September 4, 2026

RE: NC Wakeboat – 143 Holly Springs Church Rd, Broadway NC 27505
Additional field verification of as-built construction

FDR Project No.: 24-067

FRONT ELEVATION
scale: 1/8" = 1'-0"

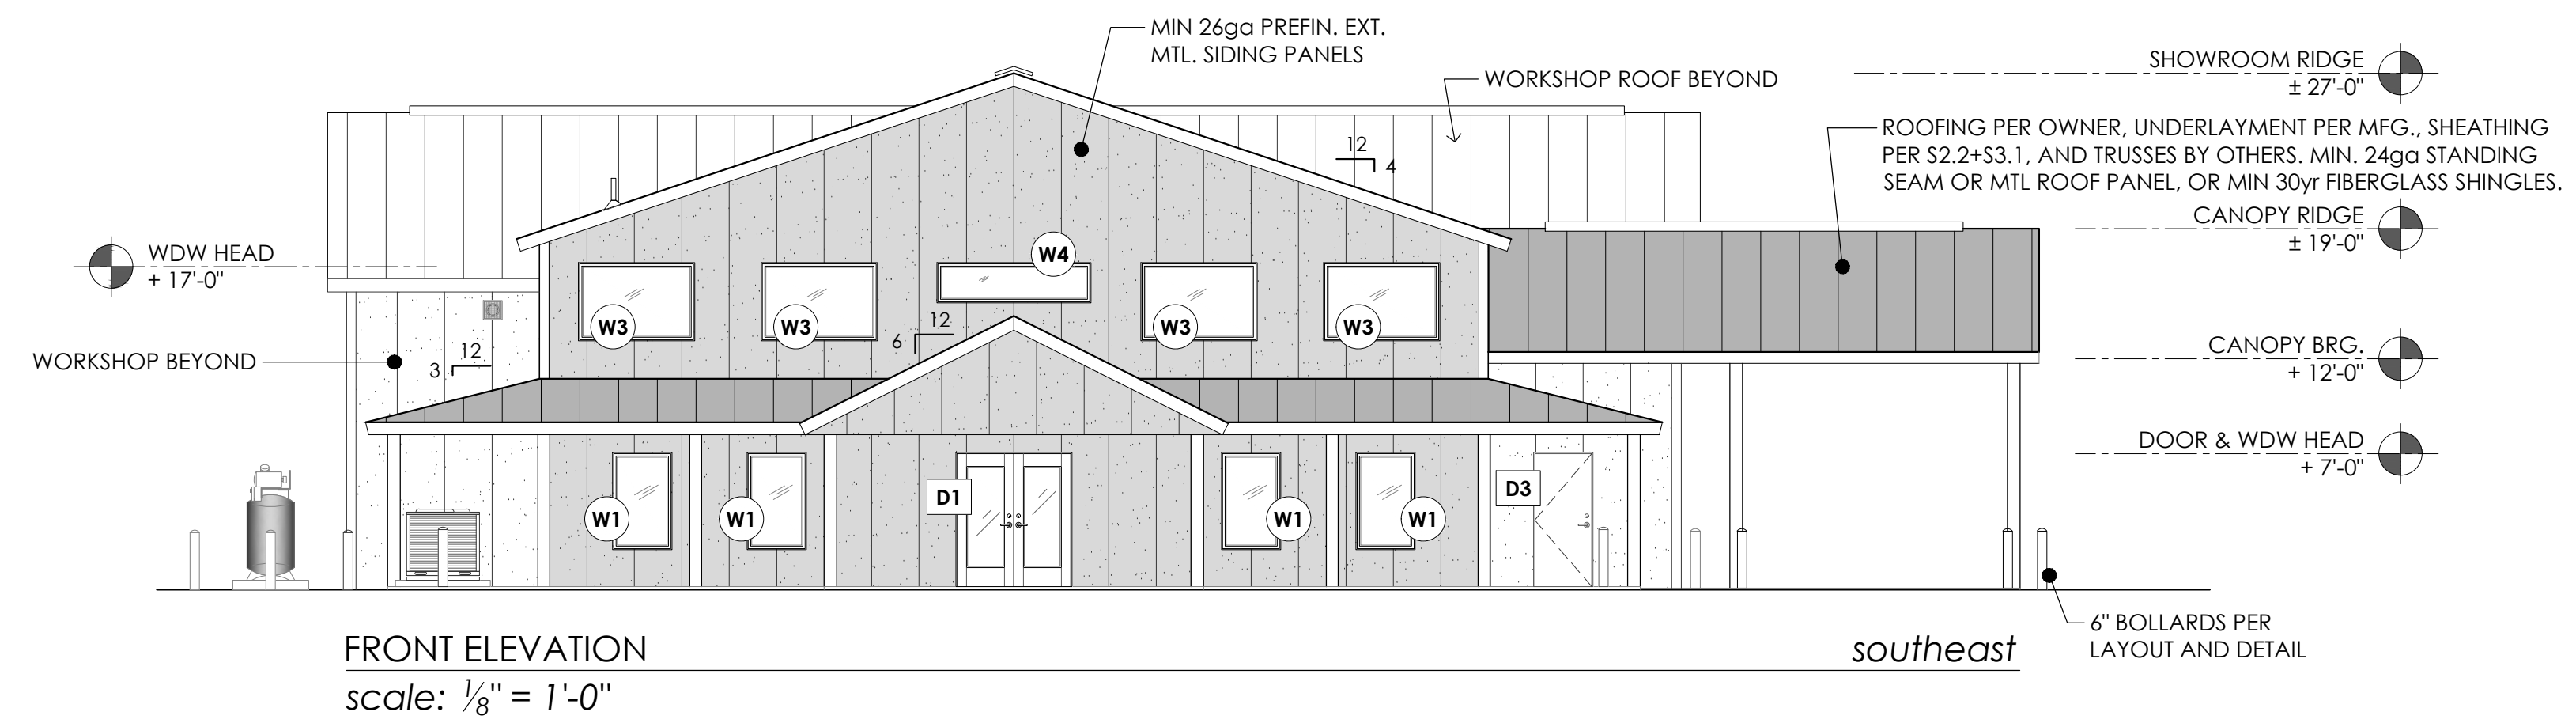
- **8x8 treated posts used as beams along front porch:**

It was observed that solid-sawn 8x8 posts were used as beams along the front porch as opposed to the framing as shown on the structural plans. While this is not generally recommended given the reduced capacity of lumber used in the “flat use” load-case, in this case, the short, 8’ max spans were reviewed, and the as-built framing was found to be acceptable as-installed in this specific case.

**2 PROPOSED MEZZANINE LAYOUT**  
scale: 1/8" = 1'-0"

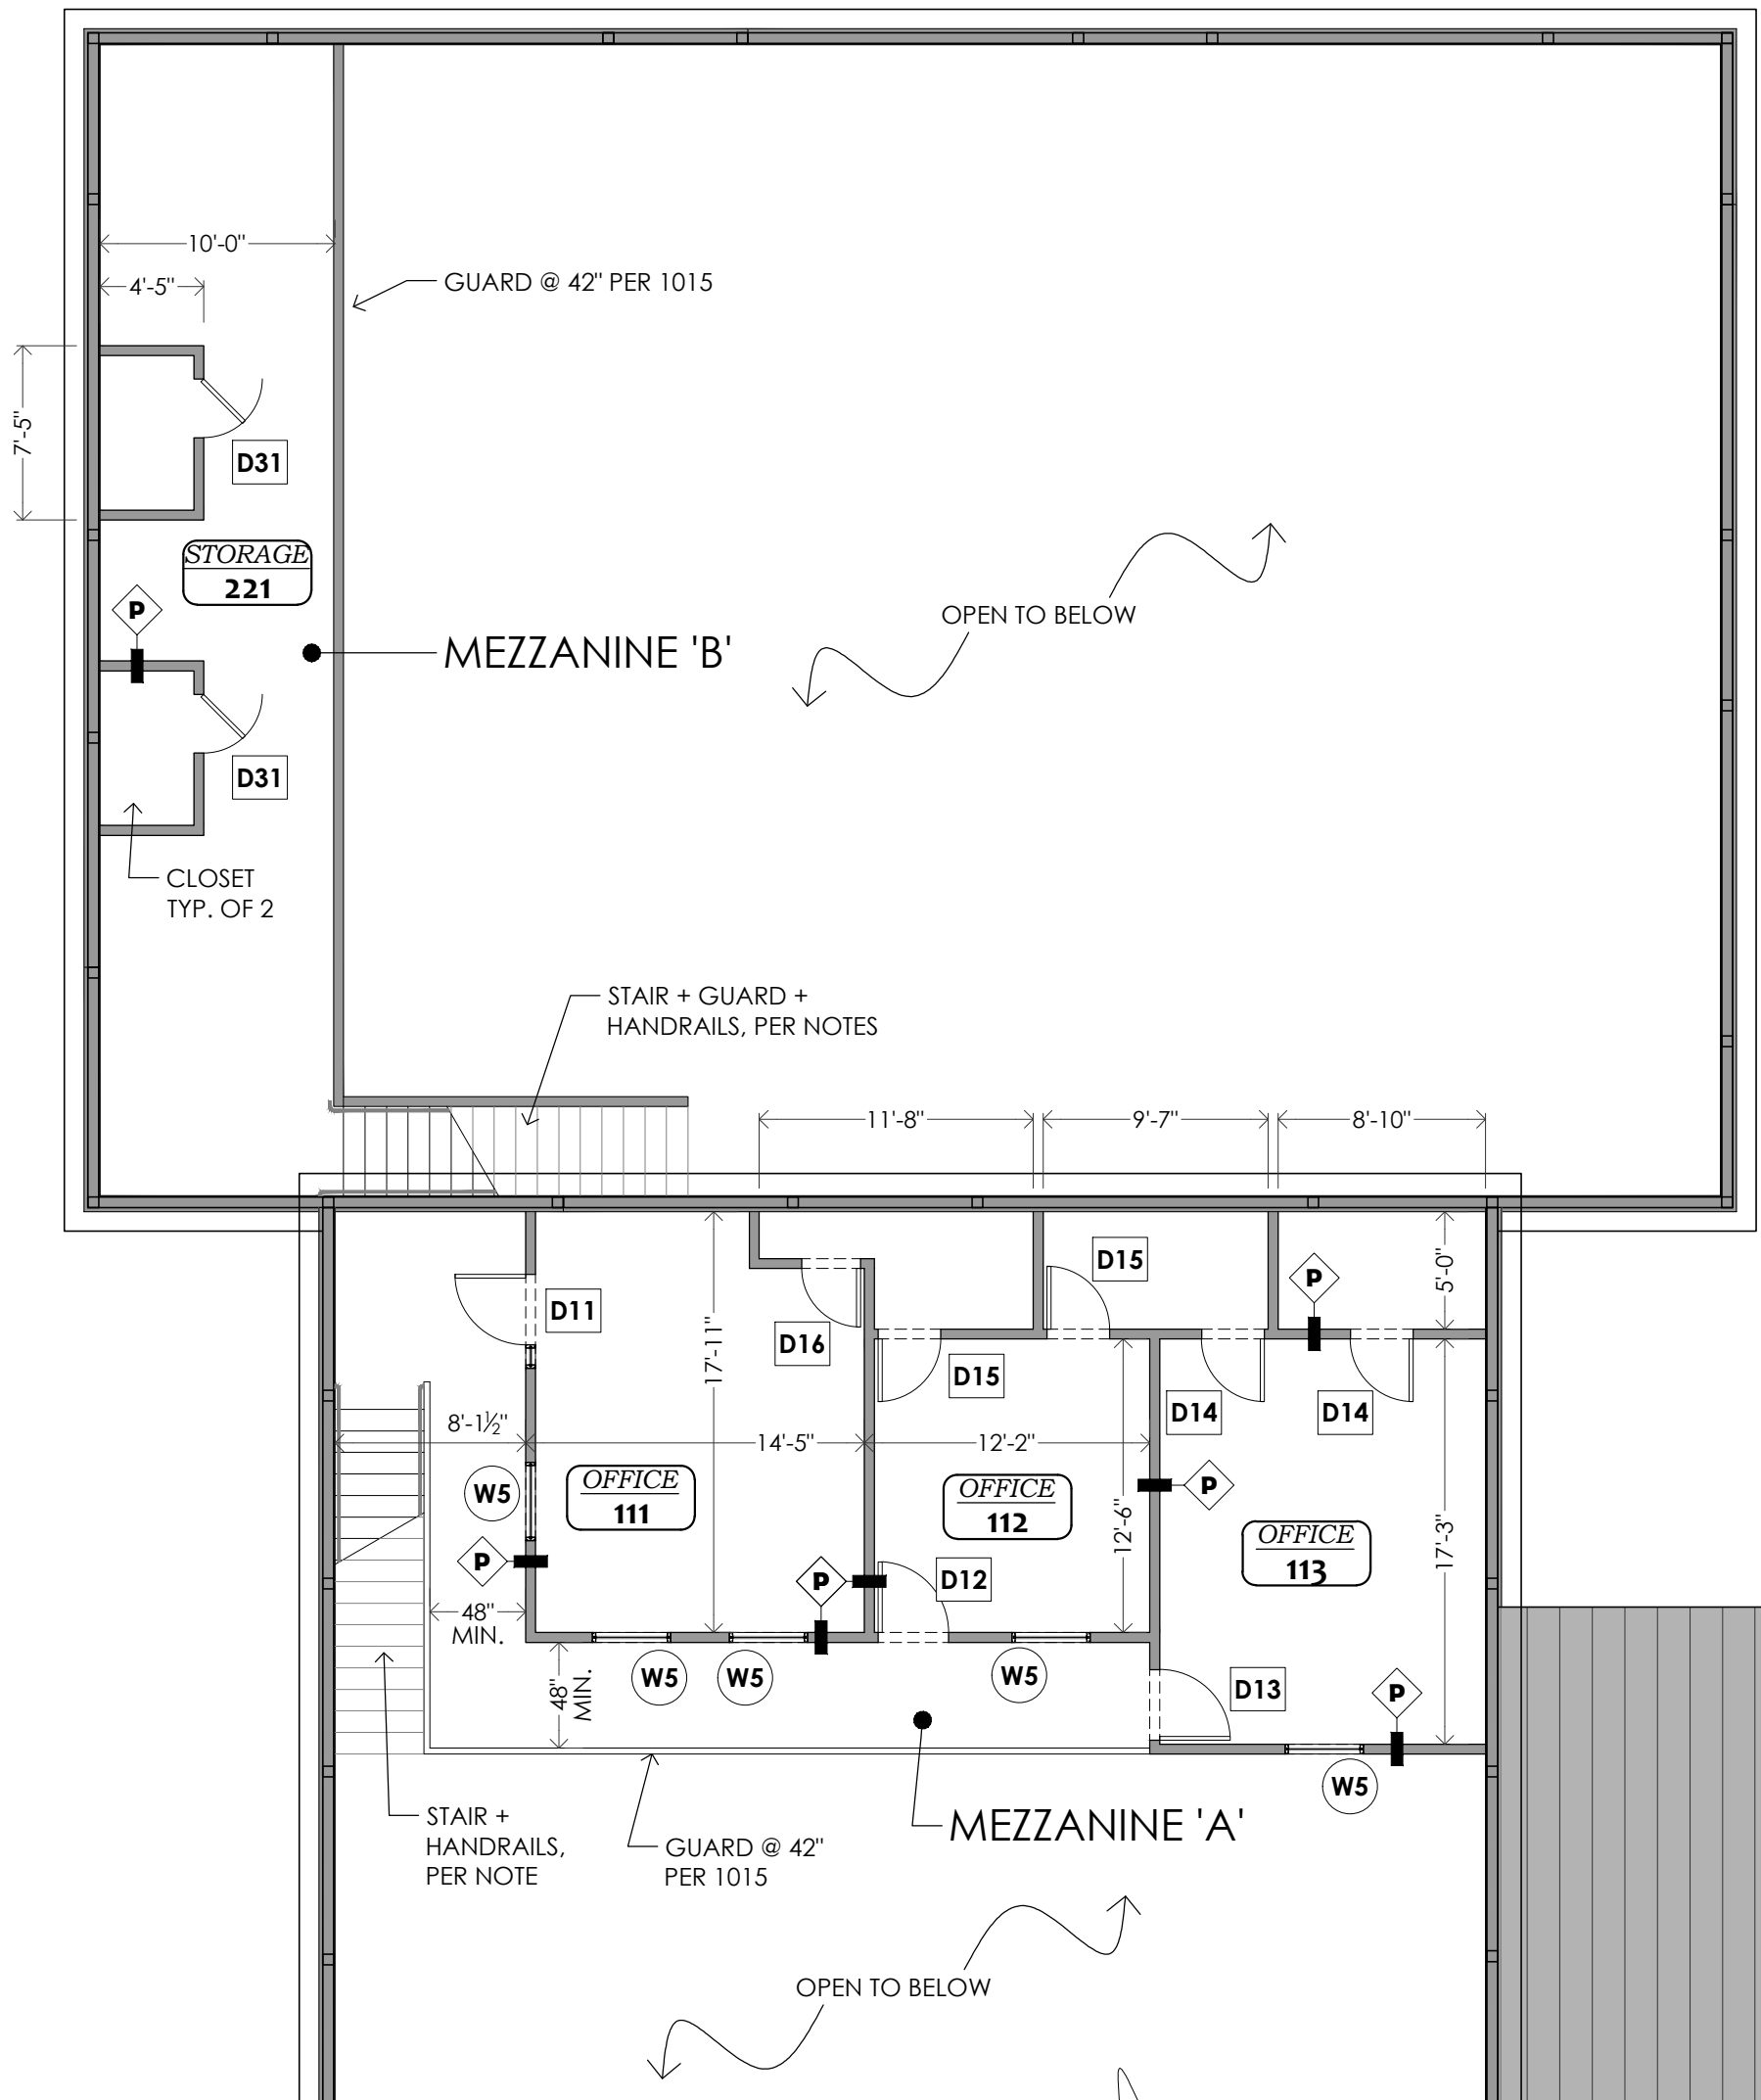
- **Lug Footing under mezzanine:**

As previously established, the addition of the interior mezzanine was constructed without plans, and without the previous knowledge of FDR Engineers. We “reverse engineered” the as-built mezzanine for verification of the framing, however with that being said, and again, as established initially, there is no thickened slab, or other foundation considerations provided below the mezzanine bearing walls. With that said, the existing 6” concrete slab, to include WWF reinforcing was determined adequate to support the imposed load, though with the likely caveat that surface cracking will develop once the mezzanine is occupied. The owner is aware of this fact, as well as the fact that this cracking does not indicate impending structural collapse but is simply a cosmetic concern.
